From: Laura Gibbons
Sent: 20 March 2019 13:48
To: Planning.Responses
Cc: David Easton
Subject: RE: Planning Consultation on: BE/29/19/PL

Engineers Comments Regarding Surface Water Drainage

APPLICATION **BE/29/19/PL**

Description of Works: Erection of 99 No. dwellings together with landscaping, open space & associated works. Access to be taken from New Barn Lane(Alternative application).

drawing no: LIN22349 11 Sheet 6

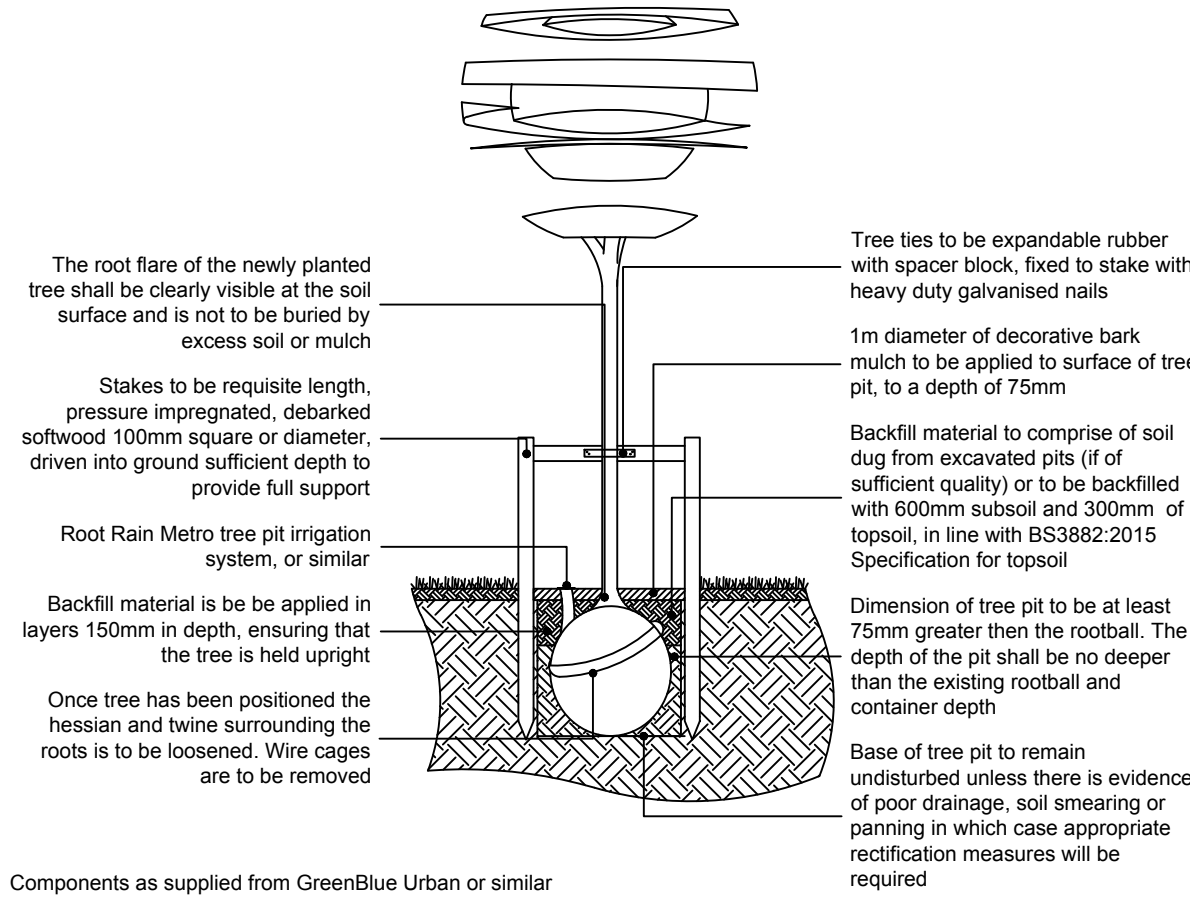
4. Please ensure that the northern attenuation tanks and shrub proposals are also reviewed.
5. There is conflict between Landscape proposals LIN22251 11D Sheet 6 and the drainage design (Drainage Design 99 unit scheme- sheet 1 (Alternative Approach)). Specifically at SW16 which is also the proposed location for 1No Betulla albosinesis. A catchpit manhole cannot be constructed at the same location as a tree. Please remove the proposed tree.
